**Dunston Thal (Farrar) Property Rezone
Traffic Technical Memorandum
(LSC #S2540100)
May 23, 2025**

CD File No. P258

Dunston Thal (Farrar) Property Rezone

Traffic Technical Memorandum

SUNDANCE WEST MAP AMENDMENT (REZONE)

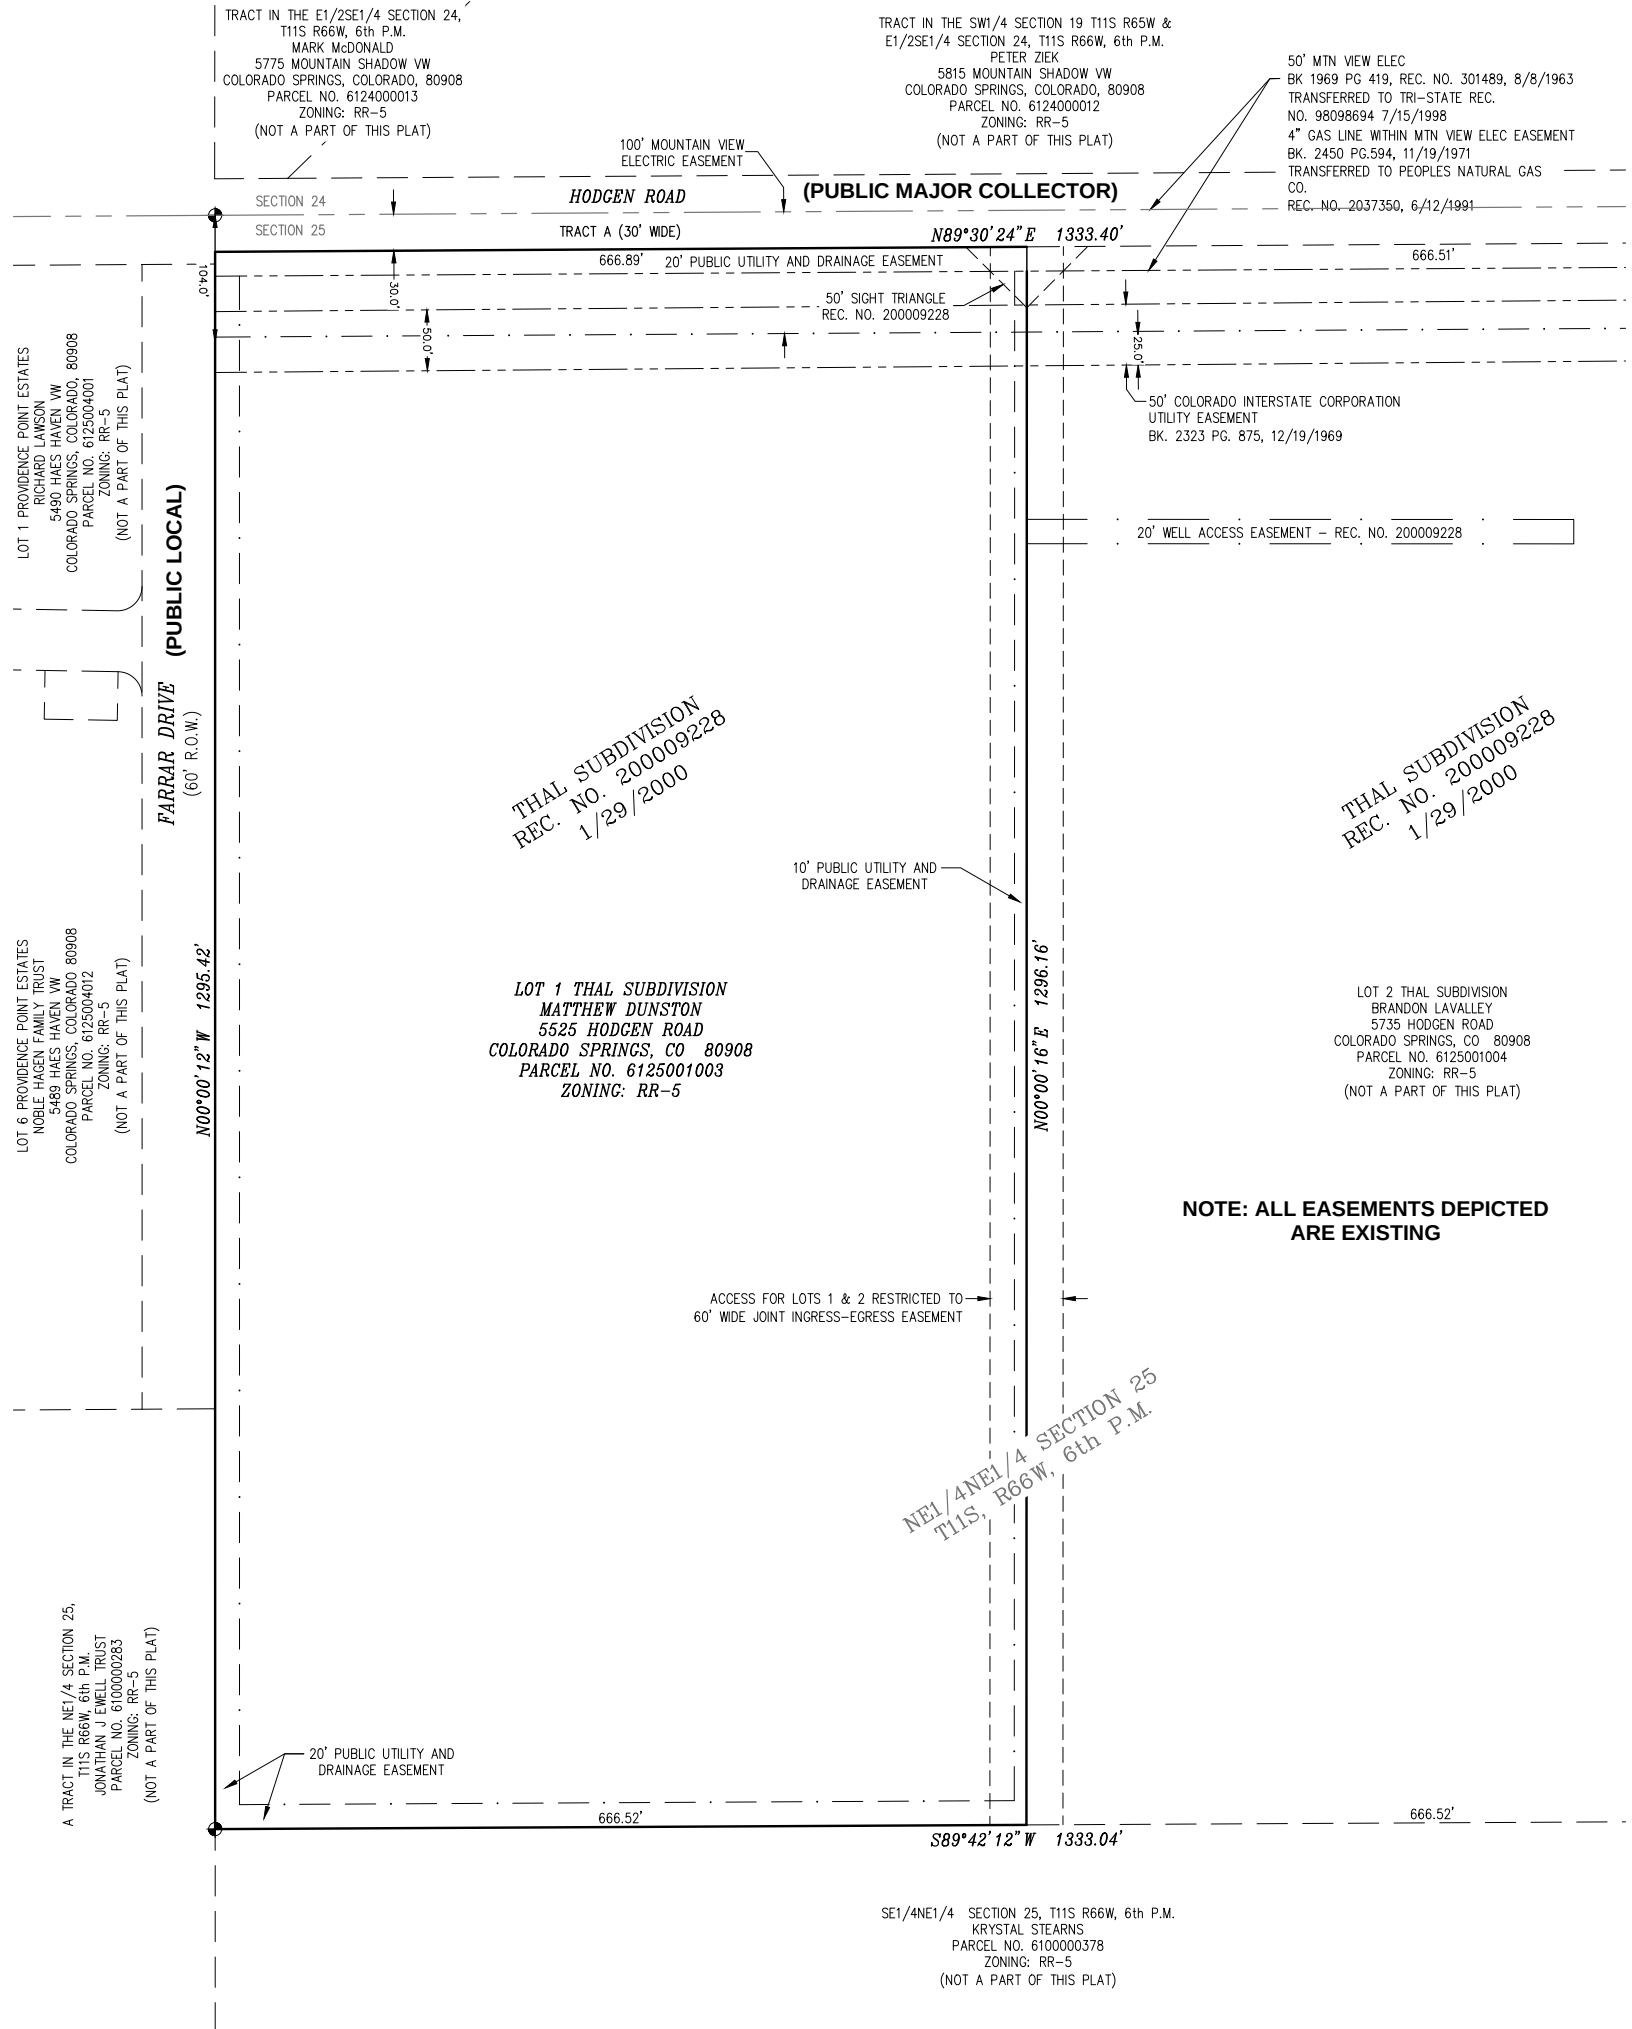
Will closing this driveway have any affect on lot 2 to the east, which shares the access easement?

Response: The developer cannot cause or require the access to be closed. Alternatively, the developer has provided an access easement for lot 2 with the concurrently submitted subdivision application in the event the County chooses to close their access in the future. The TIS has been updated to include this information.

Any additional right of way needs will be determined for Hodgen Road at the final plat as well.

Response: understood. This acknowledgement has been added to the TIS.
